Rustington Parish Council

Our Ref: CW/CH/JM/PLAN/24
Date: 31 October 2024

R/196/24/CLP - Lawful development certificate for the proposed use of land to station a mobile home granny annexe for use incidental to the main dwelling - 21 Mill Lane, Rustington

Drawn by : MISCHA
	Client : MR & MRS HUBBARD
	Drawing Title : PL PLAN
	Scale : 1:50 @ A3
	Date : 30 September 2024 14:34:11
Drawing Reference : 3500.24 - HTB- PLPL - OPT2B	
Revision Number : -

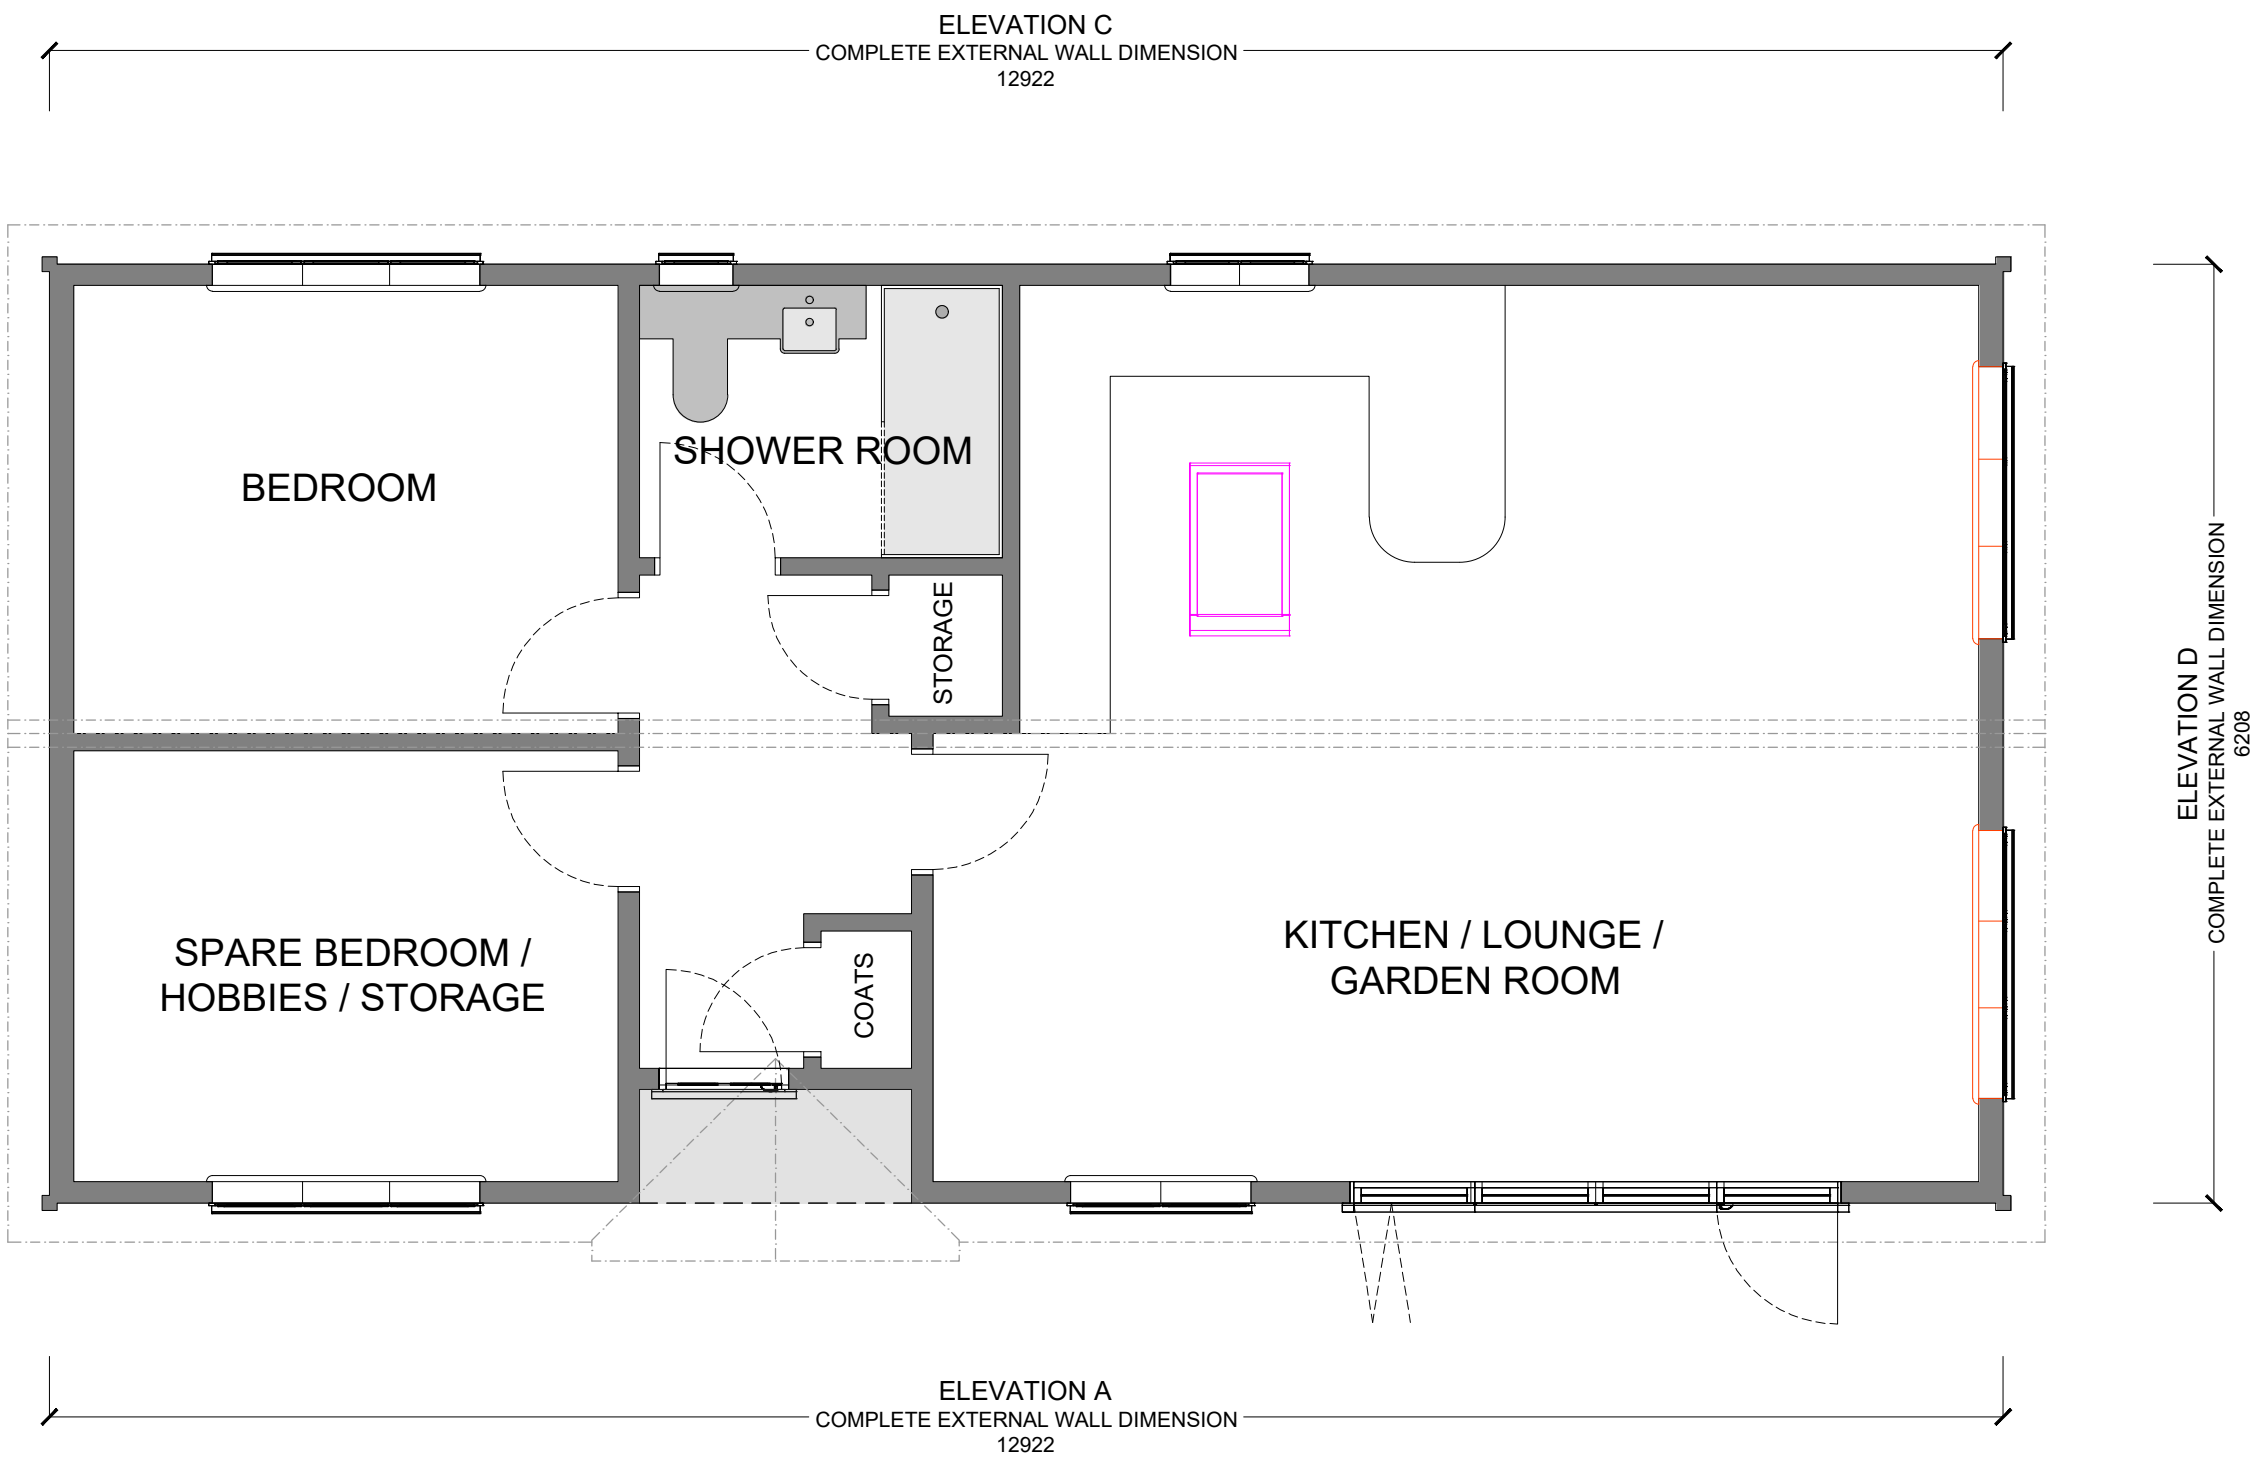
My Council has noted the above application and whilst it would not normally submit any comments in respect of Lawful Development Certificate Applications, in this instance, where the proposed large annexe appears to cover the full width of the garden, with no boundary distance shown, it feels it must register and draw your Authority's attention to its extreme concern in respect of the height of the building (Internal Height 3.05 metres, External (Proposed Elevation) 3.57 metres - 0.520 metres difference - with padstones and a 'skirt'), together with the fact that there are windows overlooking on two sides of the proposed annexe.
